# CITY OF ALBUQUERQUE

Re: Certification for Permanent Certificate of Occupancy (C.O.)  
Fire Station No. 7 [K-11/D079]  
5701 Central NW  
Architect's Stamp Dated 11/27/12

**RE: City of Albuquerque  
Fire Station No. 7 – 5701 Central Avenue NW  
Traffic Circulation (TCL) Certification**

**Re: Fire Station No. 7, Grading and Drainage Plan**

DRAWING TITLE: **GRADING AND DRAINAGE**

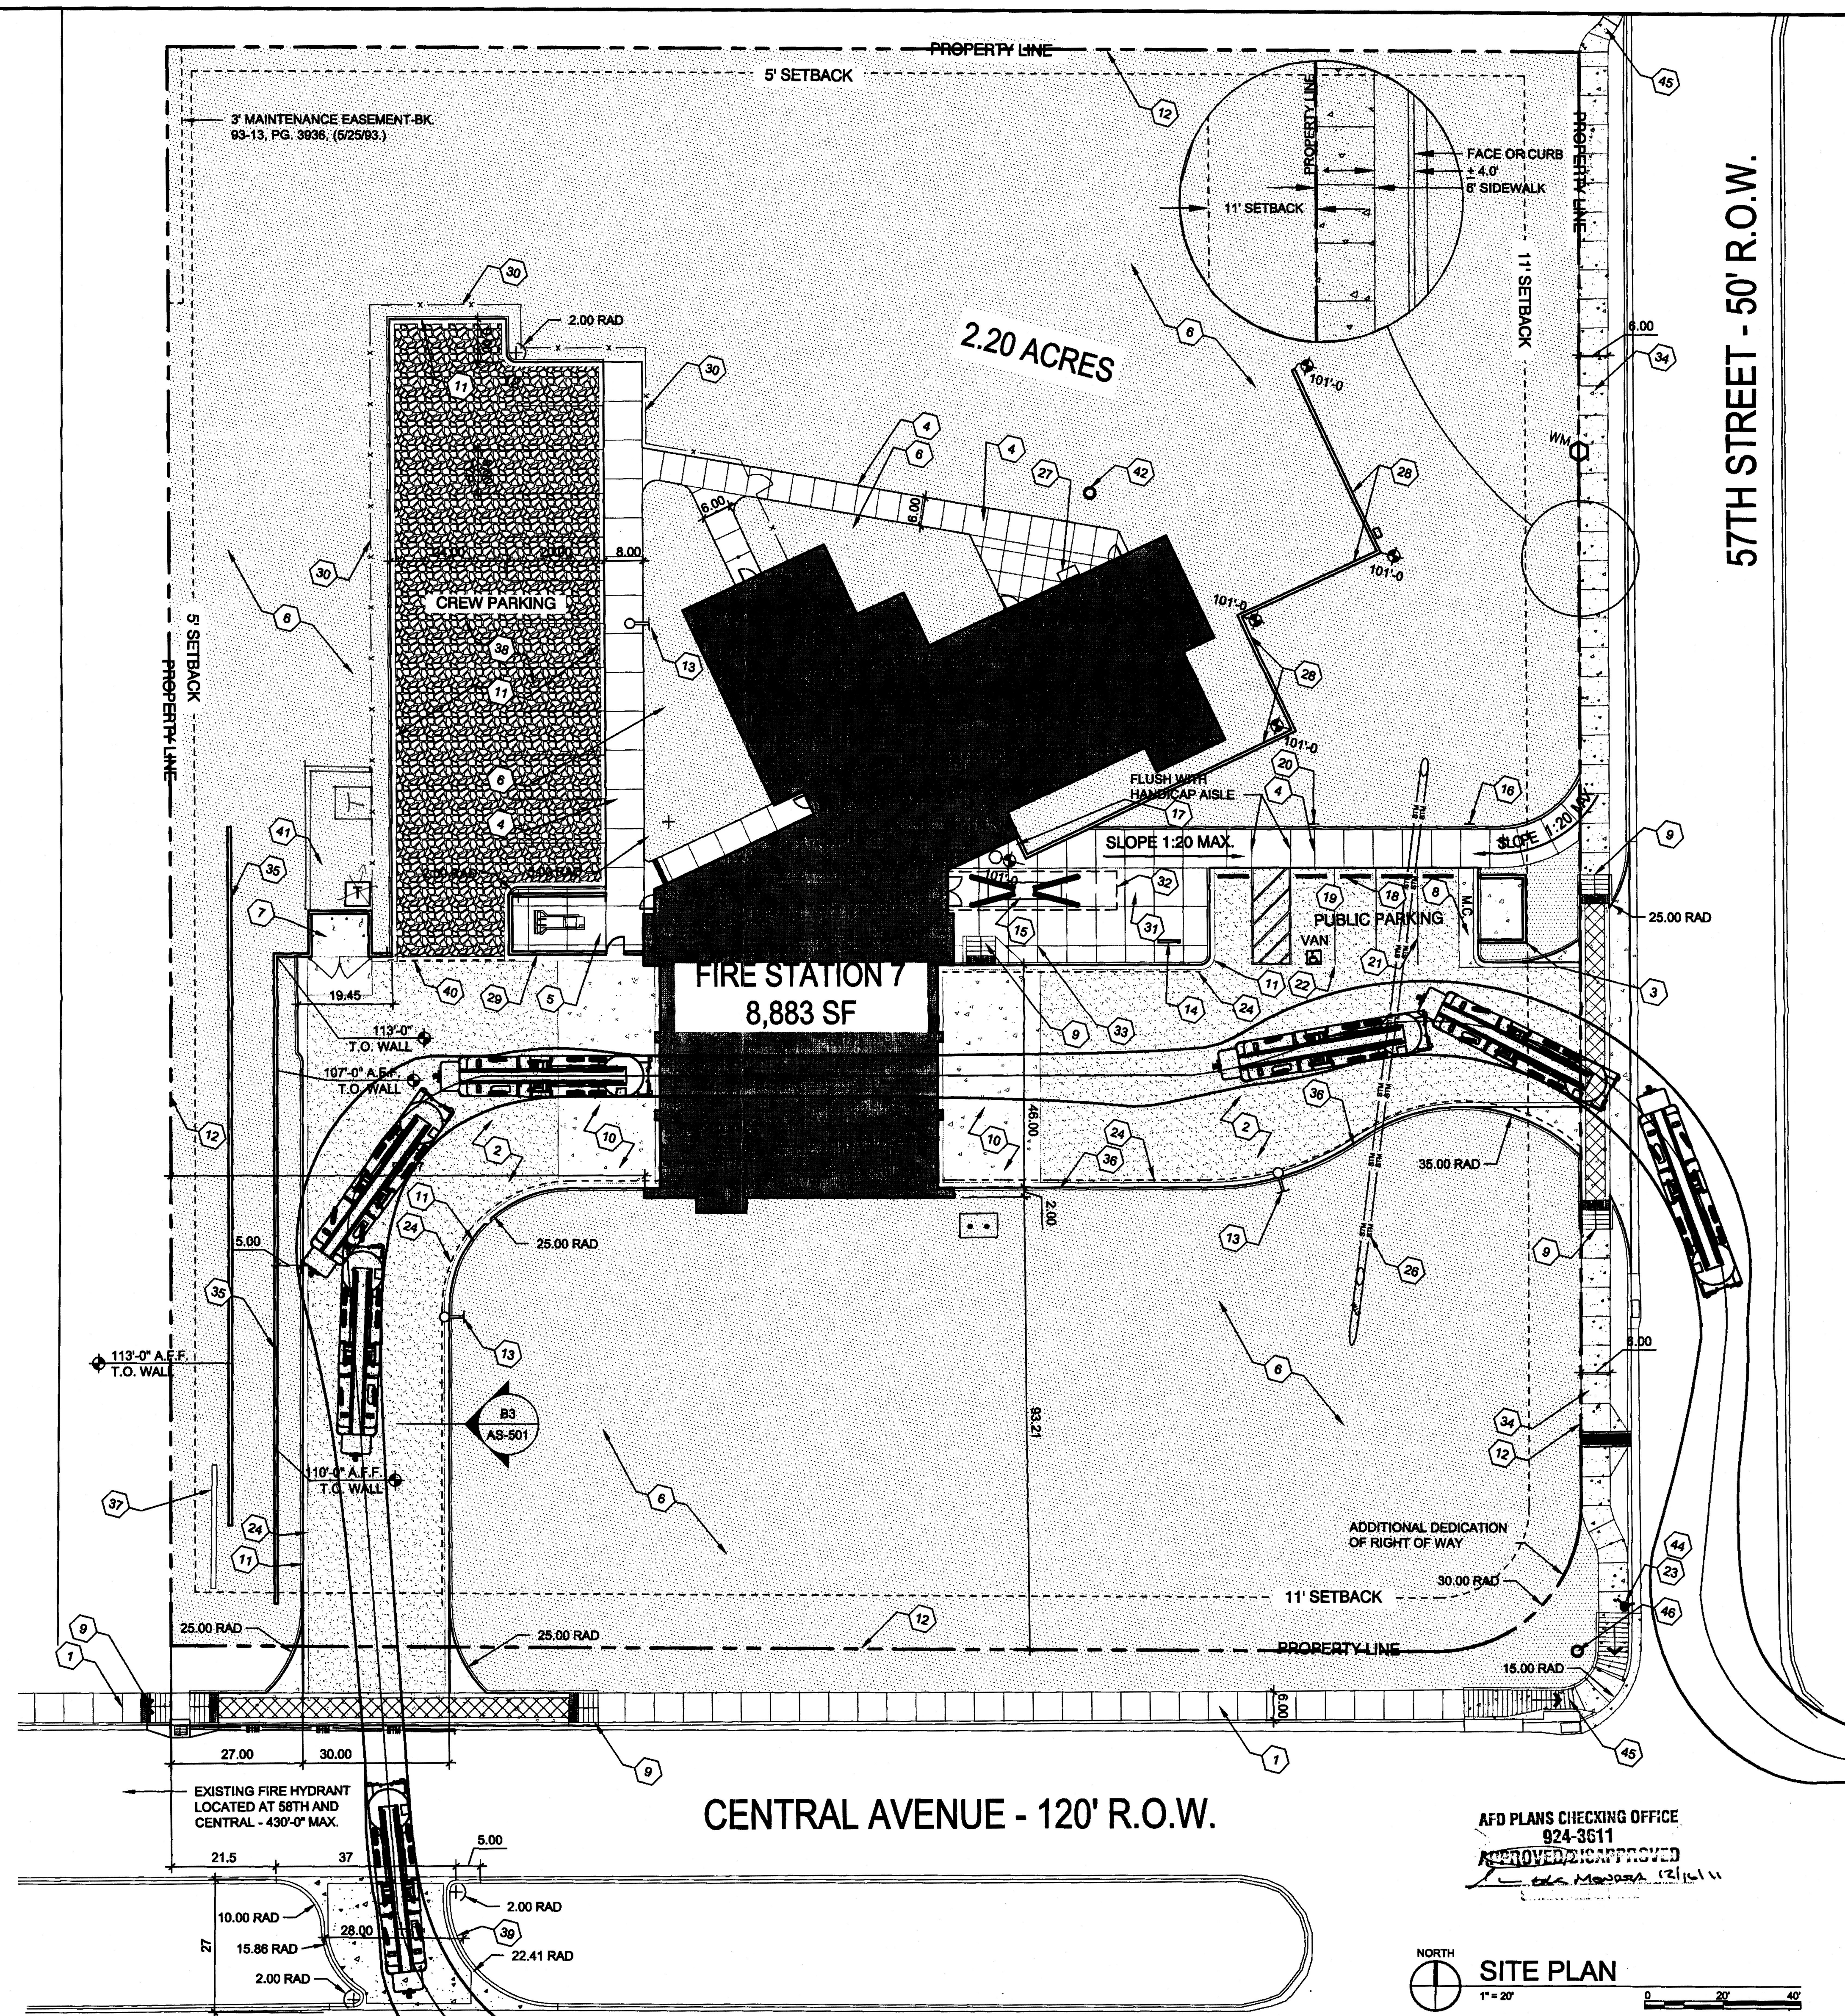
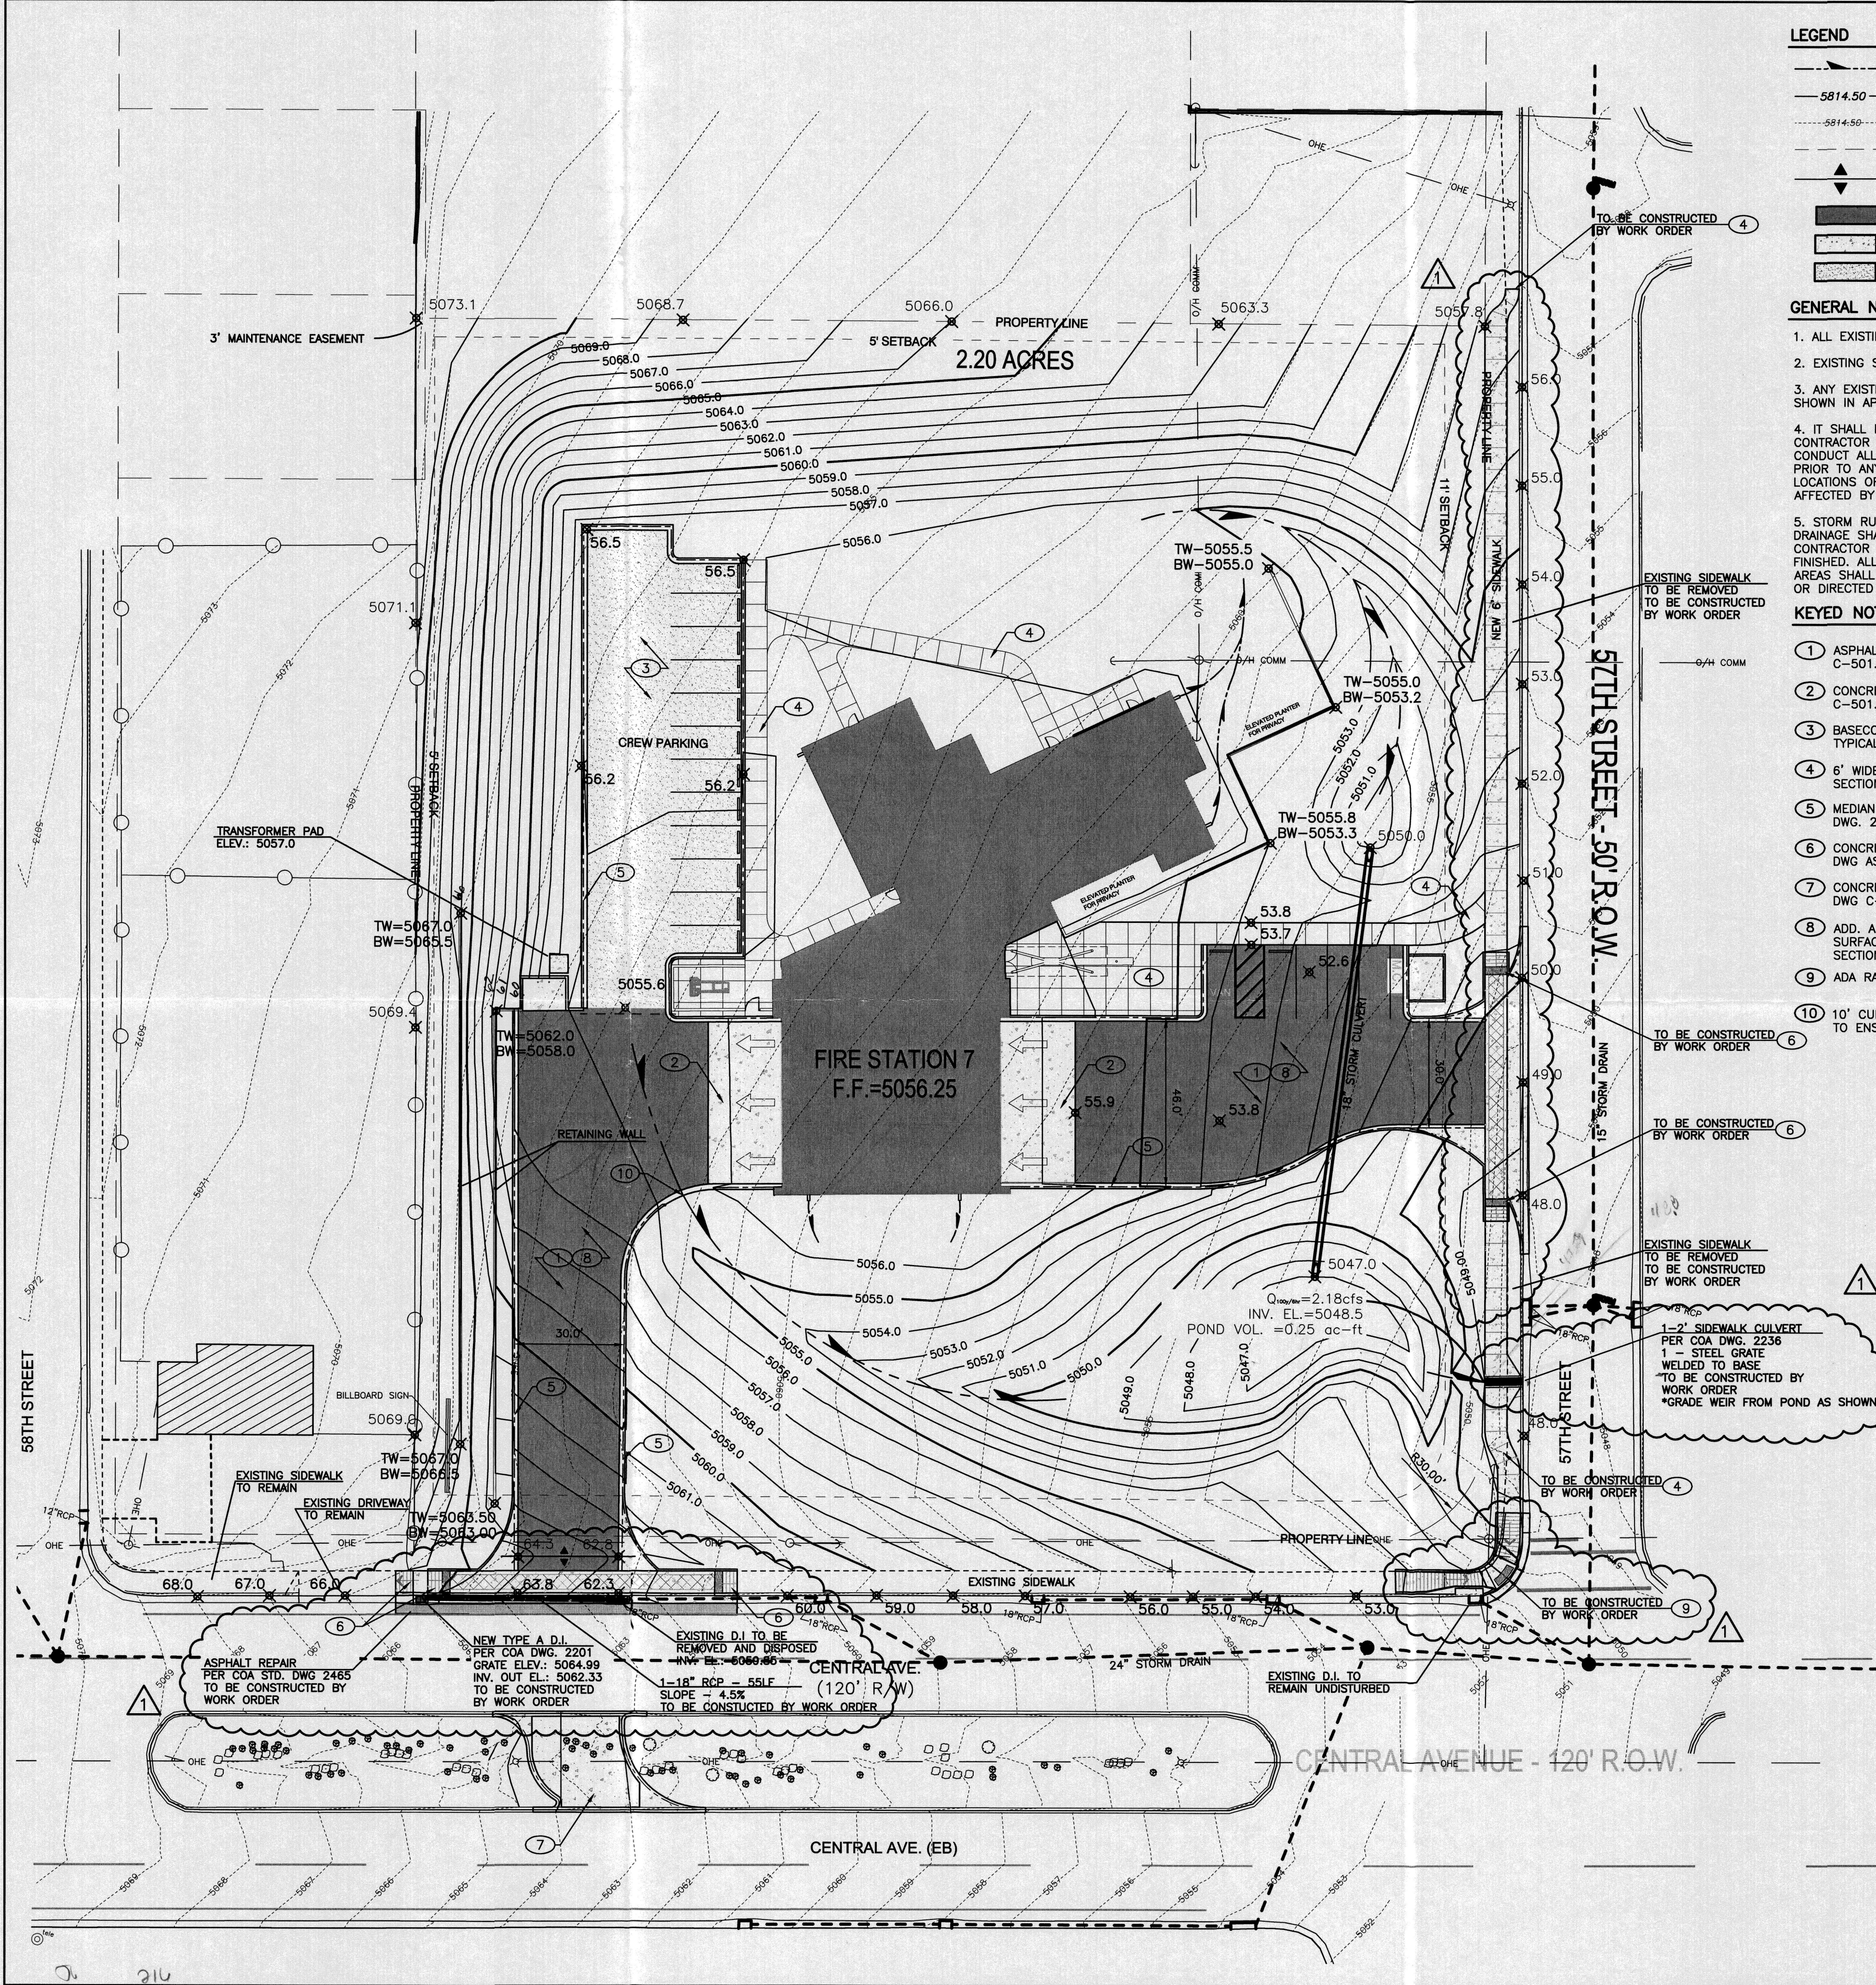
- Provide a narrative, drainage calculations and Flood Zone information.
- The items to be built by Work Order (infrastructure List items), should have a note similar to "to be constructed by Work Order".
- Add TW/BW elevations for the retaining wall east of the building.
- Hydrology approved a 2' wide sidewalk culvert on 57<sup>th</sup> St, at DRB. The capacity of these culverts is approximately 1.8 cfs/linear foot, limited by the entrance condition. What is the proposed flow to the sidewalk culvert and is it the correct size?
